CITY OF ALBUQUERQUE

April 30, 2020

Re: North Domingo Baca Multigenerational Center Phase 3
7521 Carmel NE
30-Day Temporary Certificate of Occupancy
Transportation Development Final Inspection
Engineer's/Architect's Stamp dated 4/17/09 (DRB) (C19D043A)
Certification dated 3-31-20

C1 ENLARGED SITE PLAN - PARKING
SCALE: 1" = 20'-0"

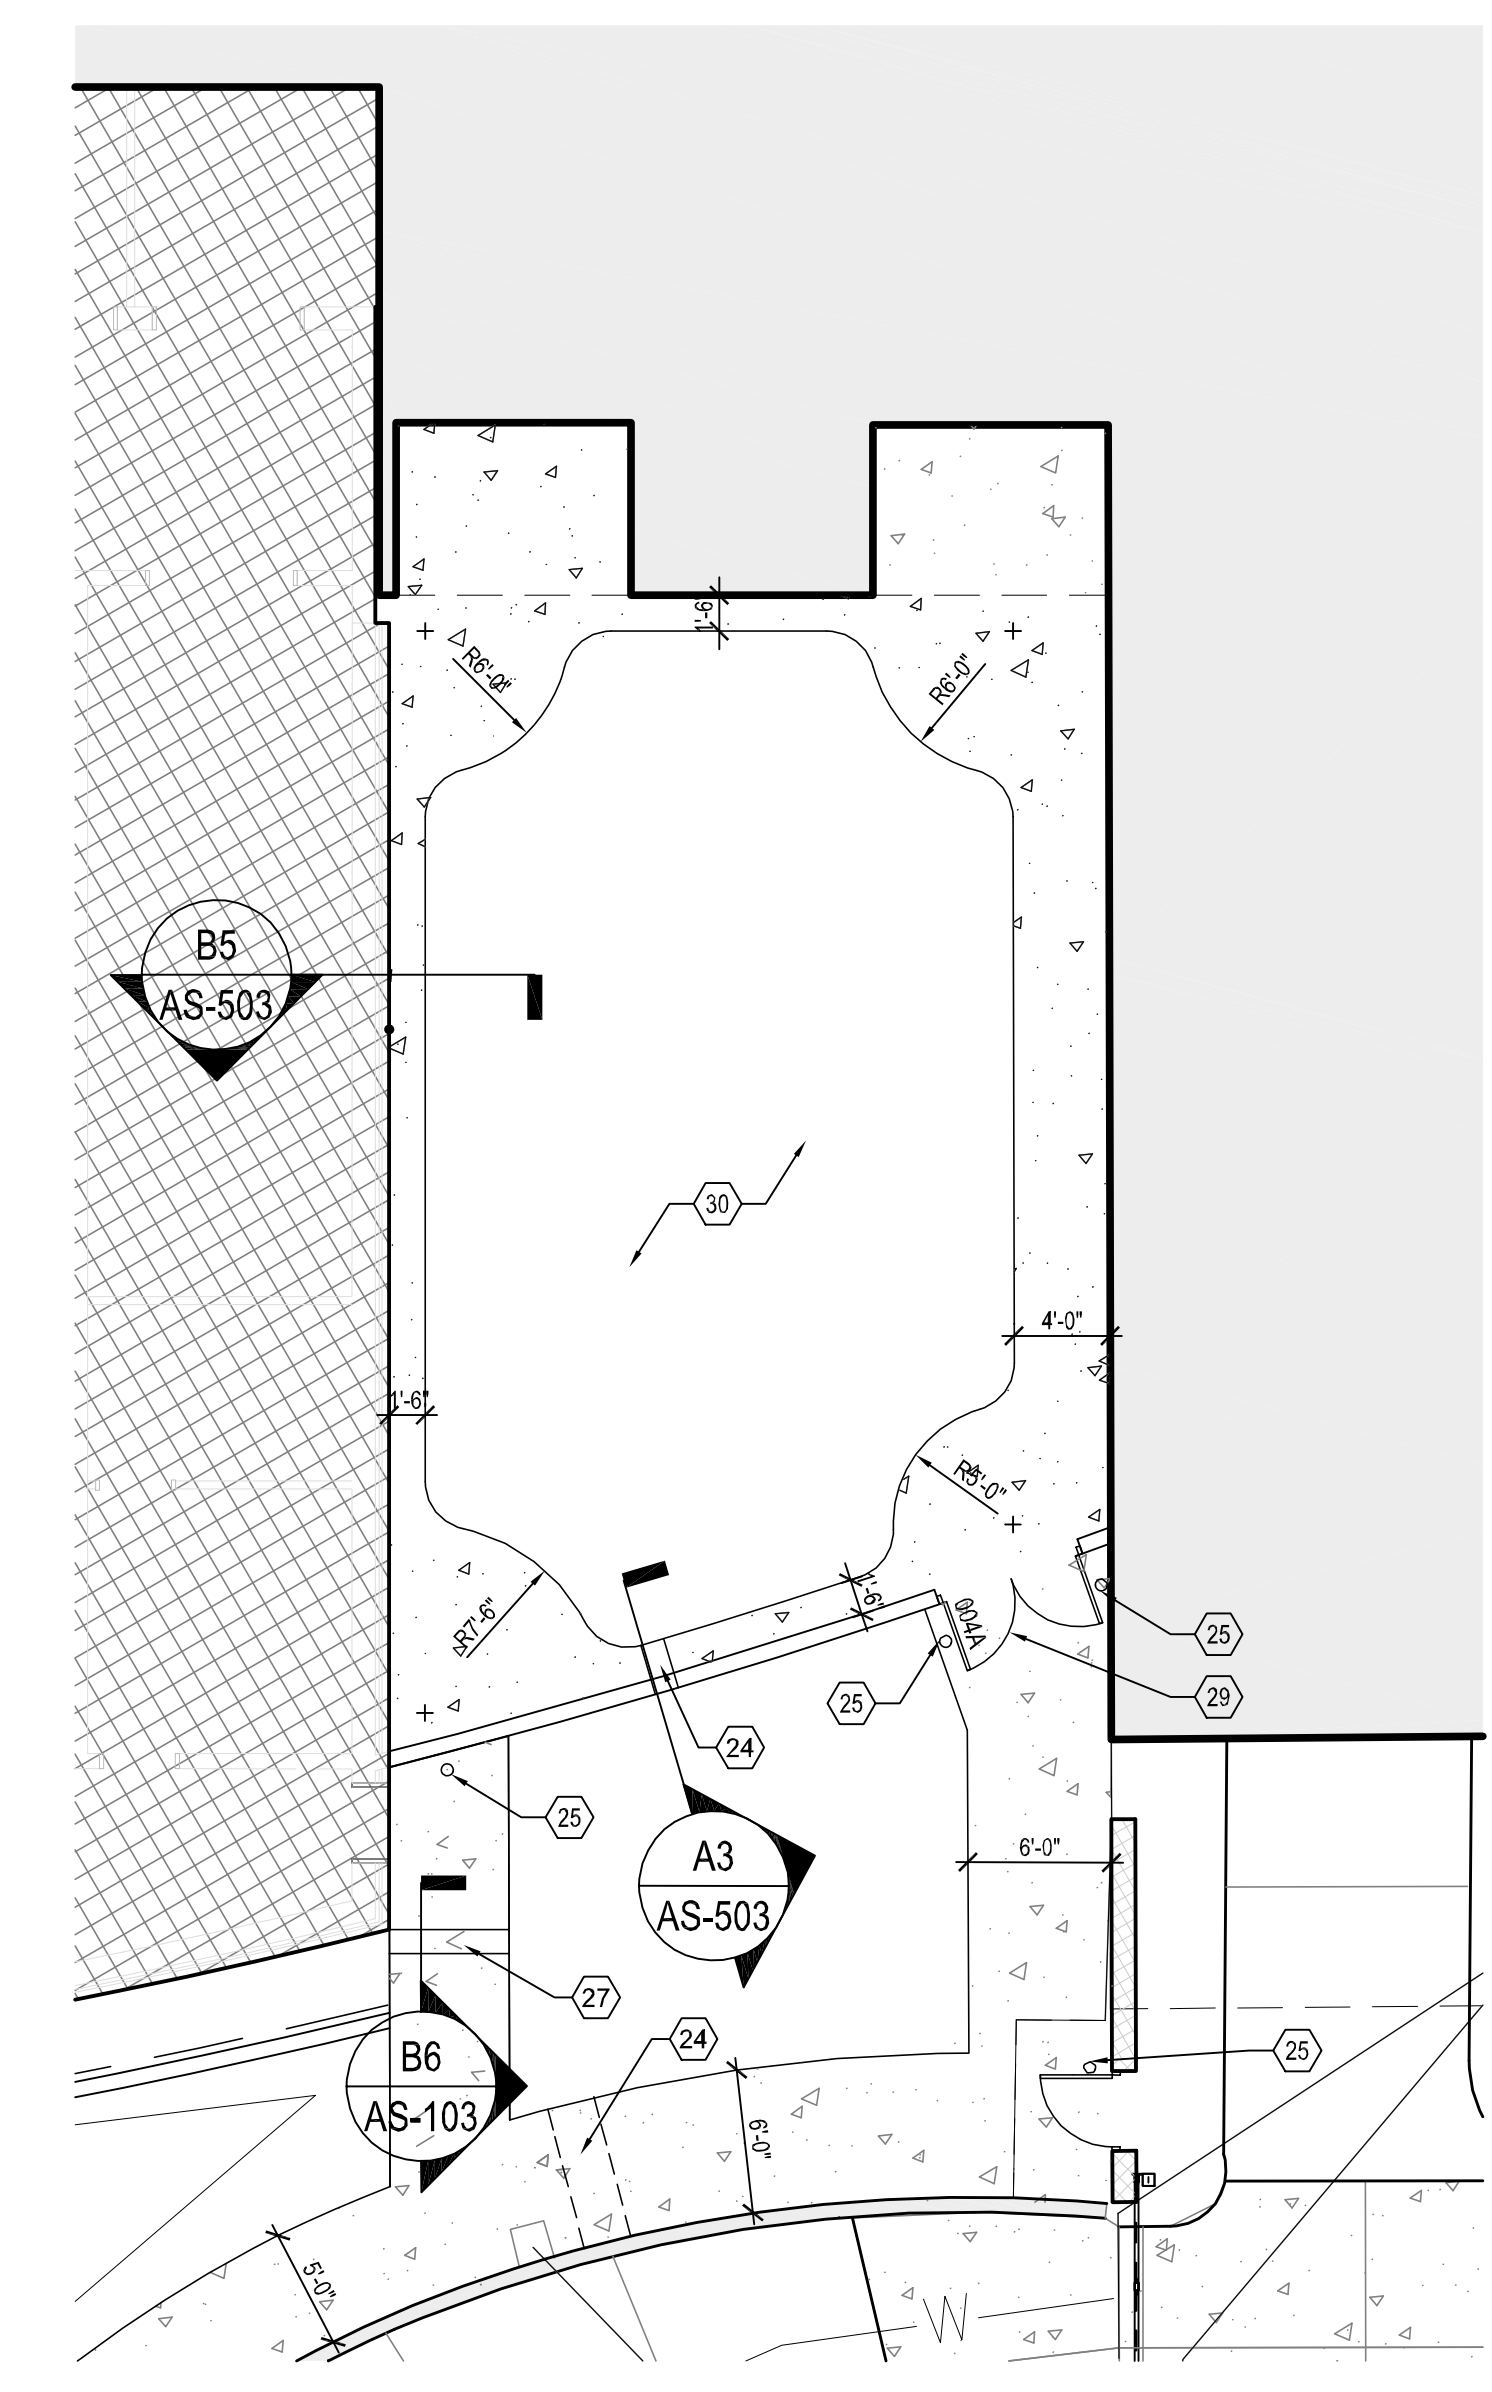
- Please update ADA signs to reflect current language. The ADA accessible parking sign must have the required language per 66-7-352.4C NMSA 1978 **"Violators Are Subject to a Fine and/or Towing."** If that language is present it is not visible in the detail.

Once these corrections are complete, email pictures showing the changes to PLNDRS@cabq.gov, and epgomez@cabq.gov for release of Final CO for Phase 3.
